From: Martyn White
Sent: 11 December 2018 17:18
To: Planning.Responses
Cc: Zac Denton
Subject: AB/109/18/HH & AB/110/18/L

AB/109/18/HH & AB/110/18/L

The proposed site is a low-level courtyard space for a large property located on Maltravers Street. Access to the site is directly from Tarrant Street, via an opening within a terrace of mostly three storey houses. Whilst the site is located away from the host dwelling, it is still in close proximity to a number of listed buildings. Development will still have the potential to affect the settings of listed buildings and the character of the conservation area.

DRAWING
Existing Site Sections
Proposed Site Sections
SCALE
1:100 (@A1)
1:100 (@A1)

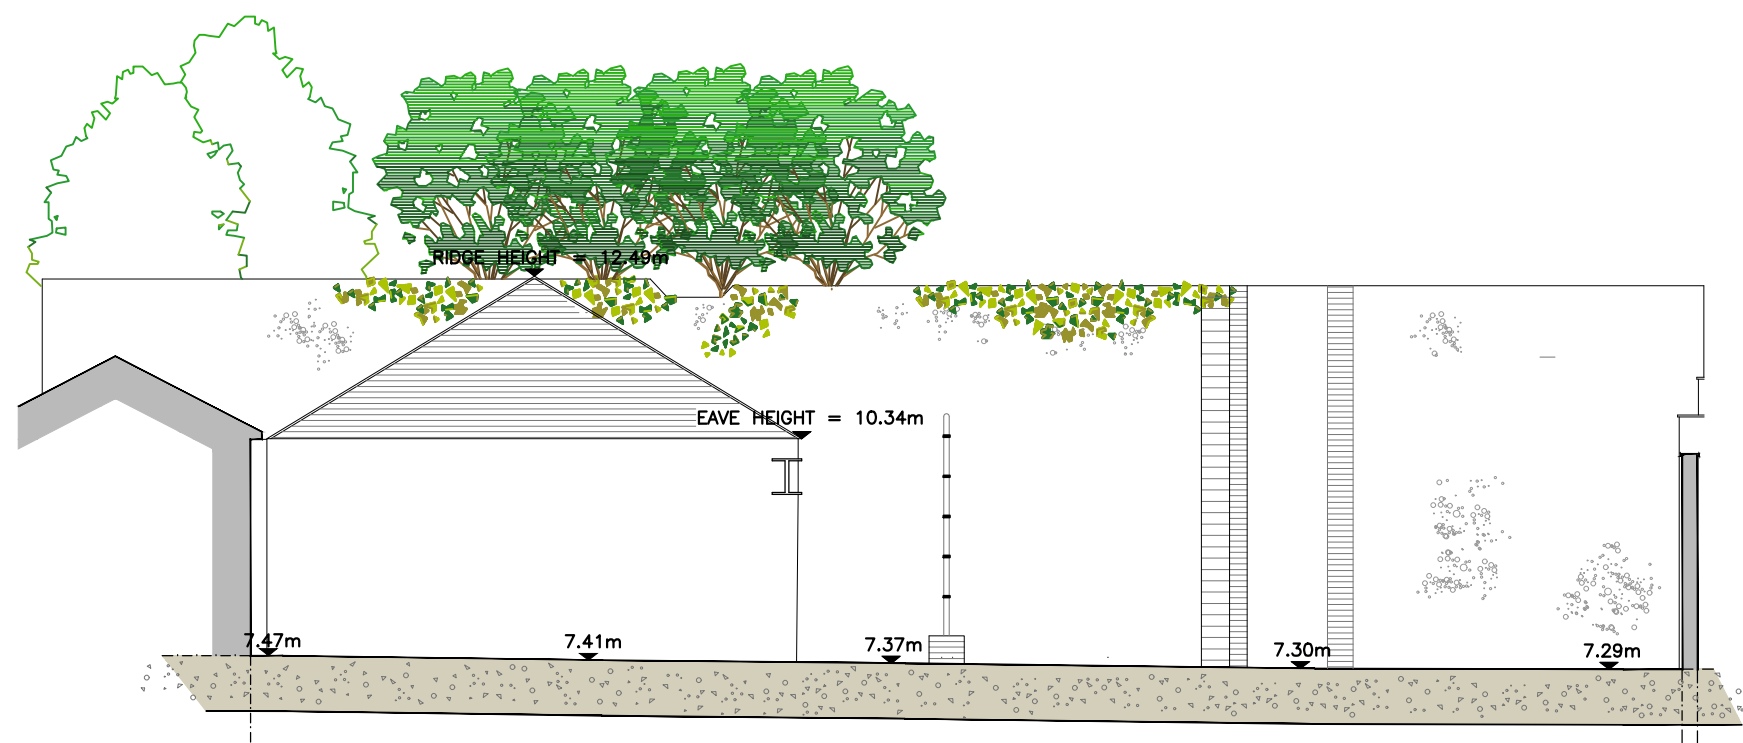
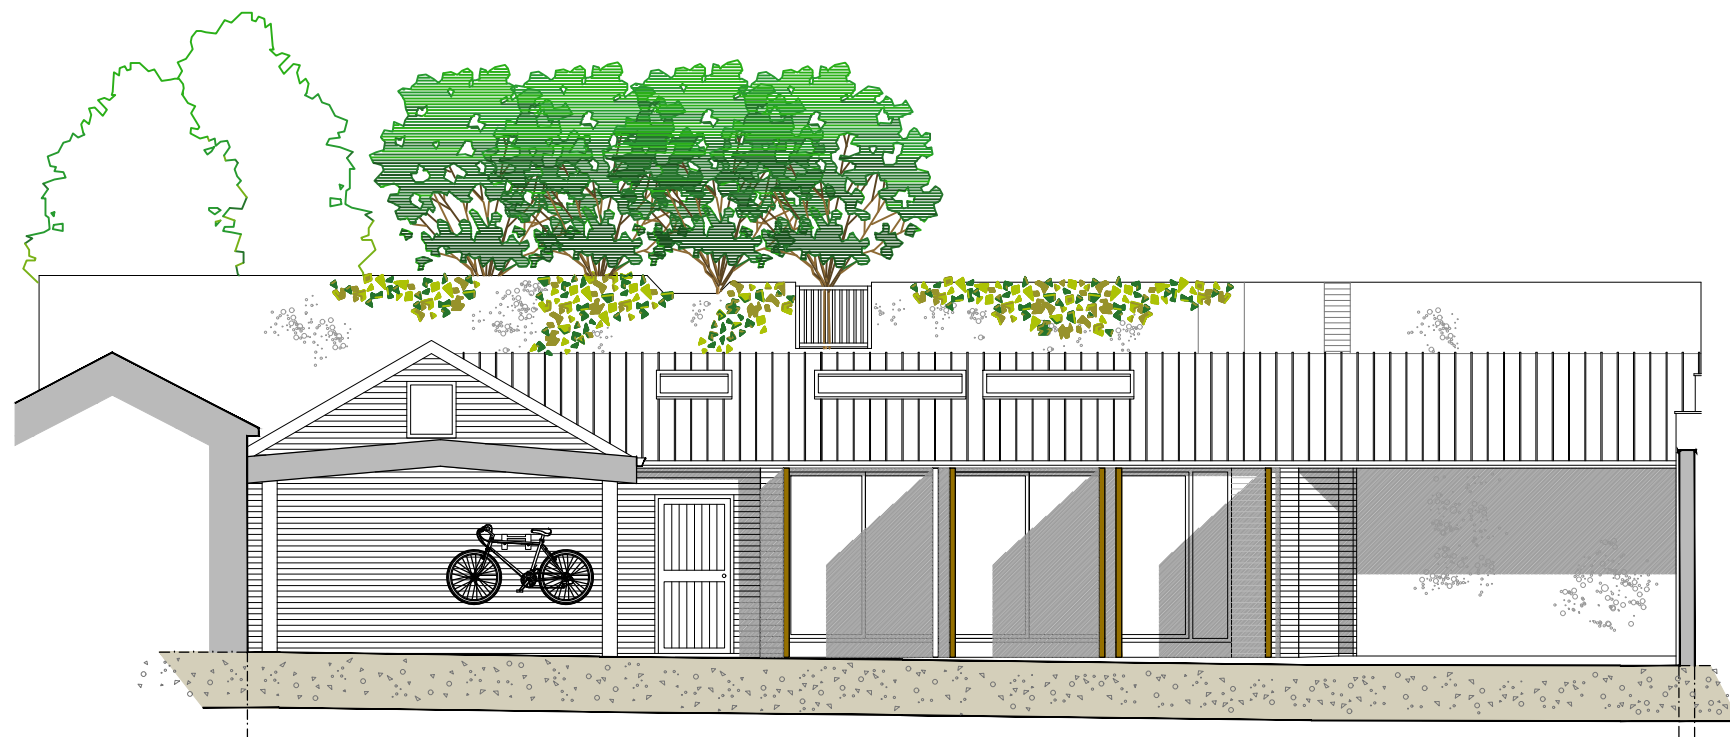
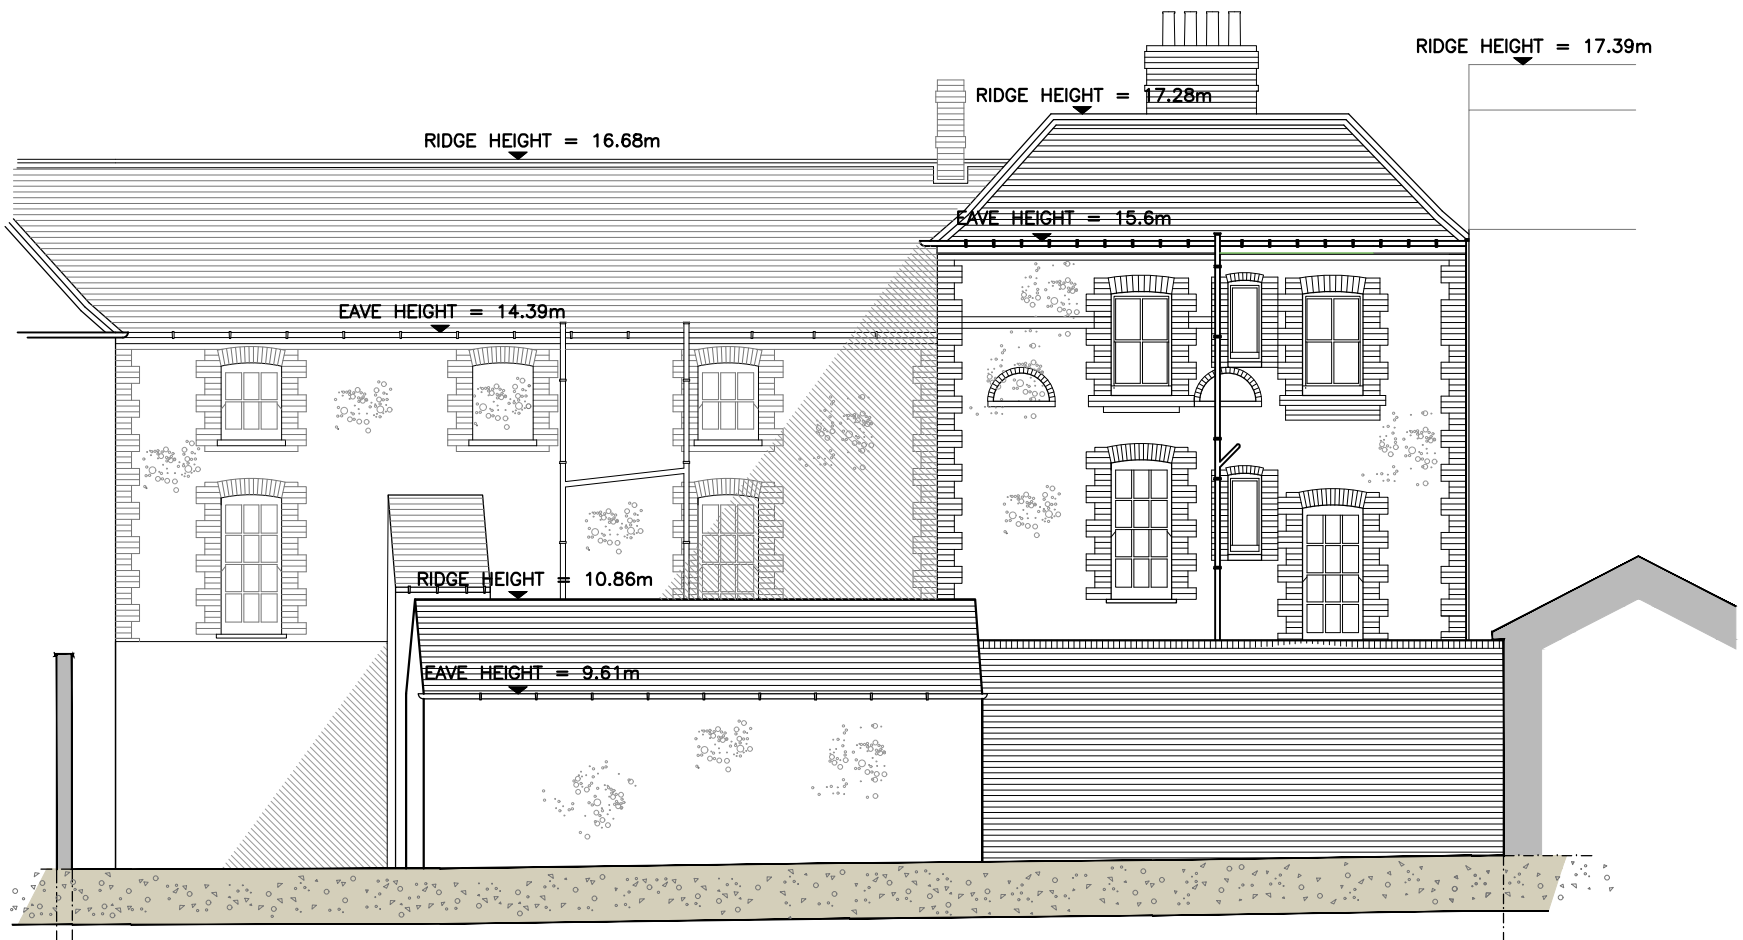
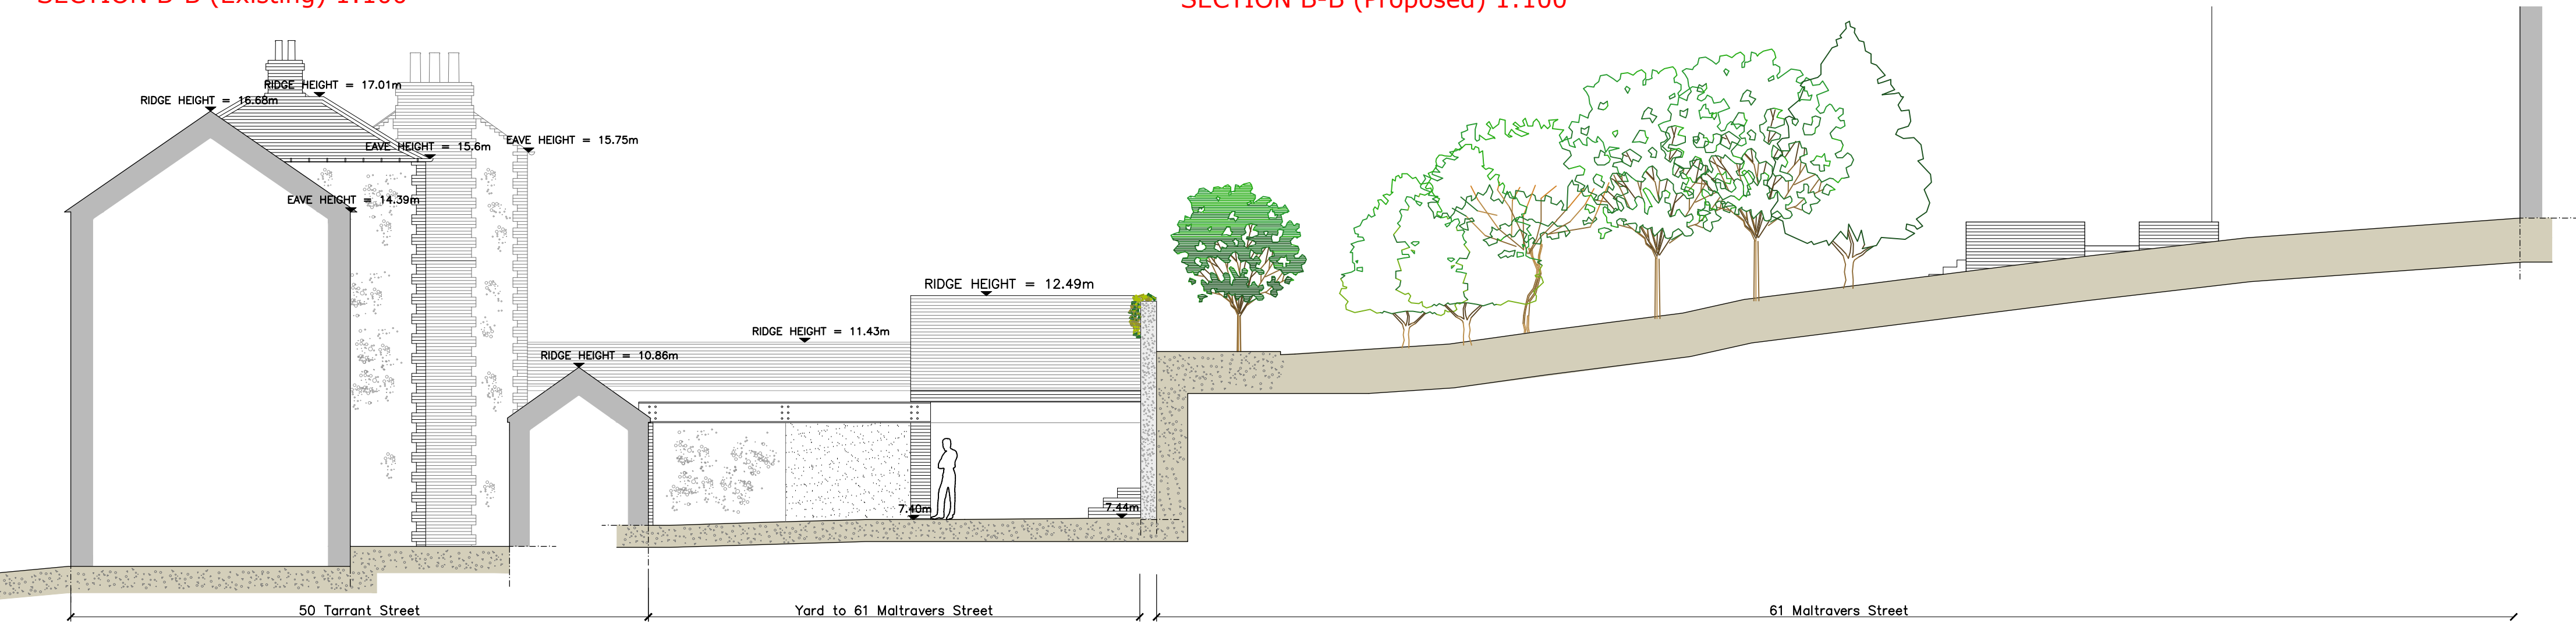
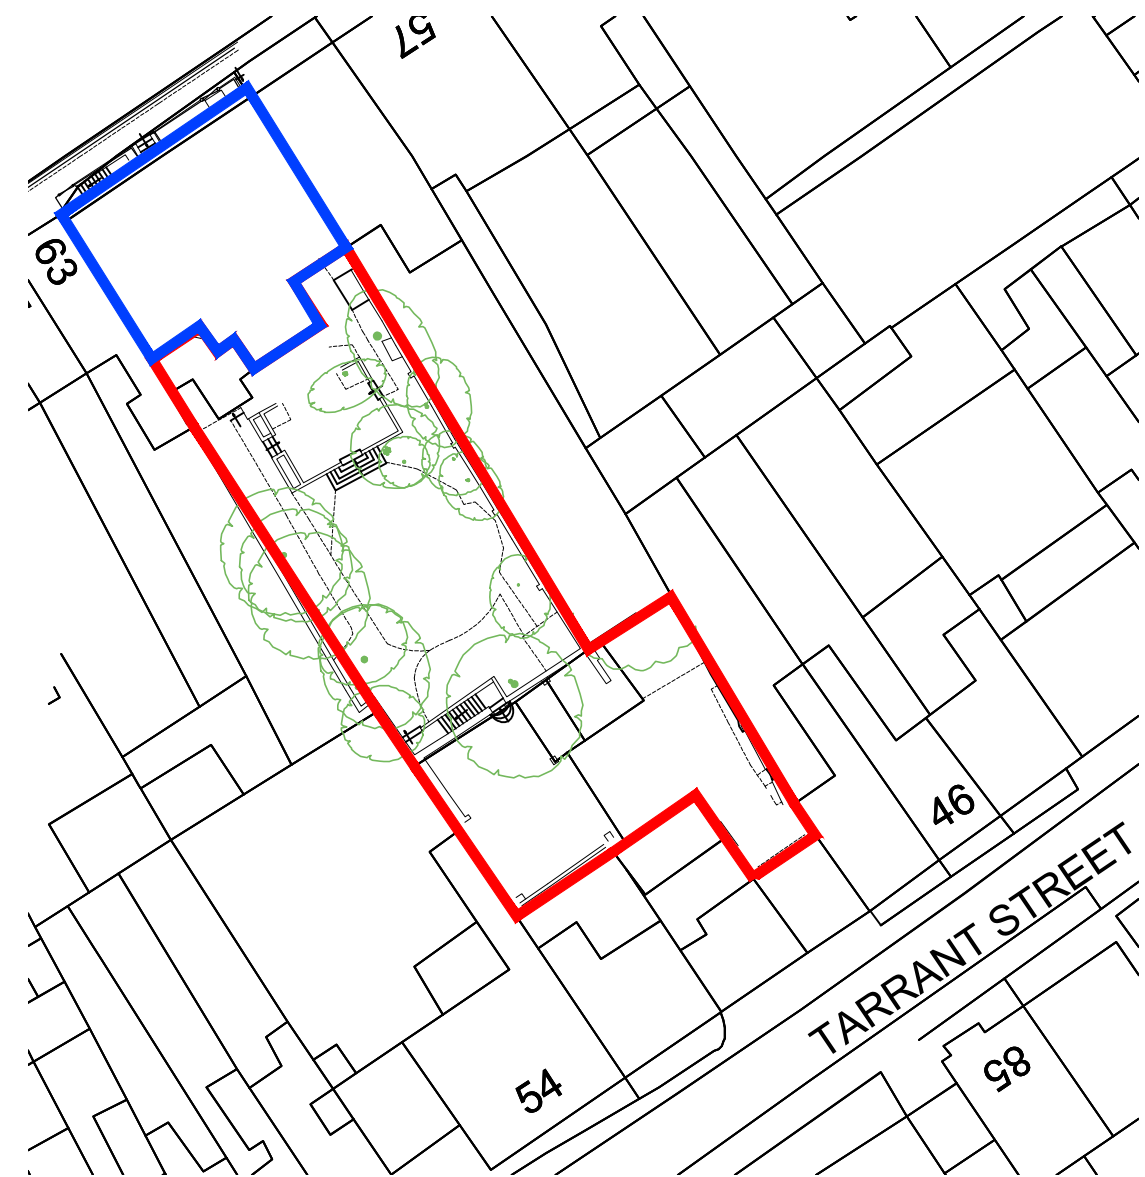
The proposed design appears to draw upon a concept of a garage/stabling block through the use of simple façade treatment and the incorporation of a series of closing garage style doors. This concept reflects the existing character of the site, along with the previous use. The success of such an element of the design will depend upon the detailing of the window/doors. It is suggested that the glazing should be set back so as to create a shadow line, which reduces the impact of the glazing.

The retention of the boundary walling where possible is supported. I also note that works of repair are proposed to part of the retaining wall for structural reasons. Whilst this element of the proposal is considered acceptable, we will need to understand the details of how the new section of walling will look. Details should be provided for by way of condition

The breeze block wall is not appropriate for its locations and I note that the proposal is to treat this with cladding. The cladding appears to cover most, but not the entire wall. Details of the cladding, its colour and how the remainder of the wall is to be treated should be provided for by way of condition.

I note that the turning area is to be covered with the same roof as the main structure. Would such a space become an additional parking space?
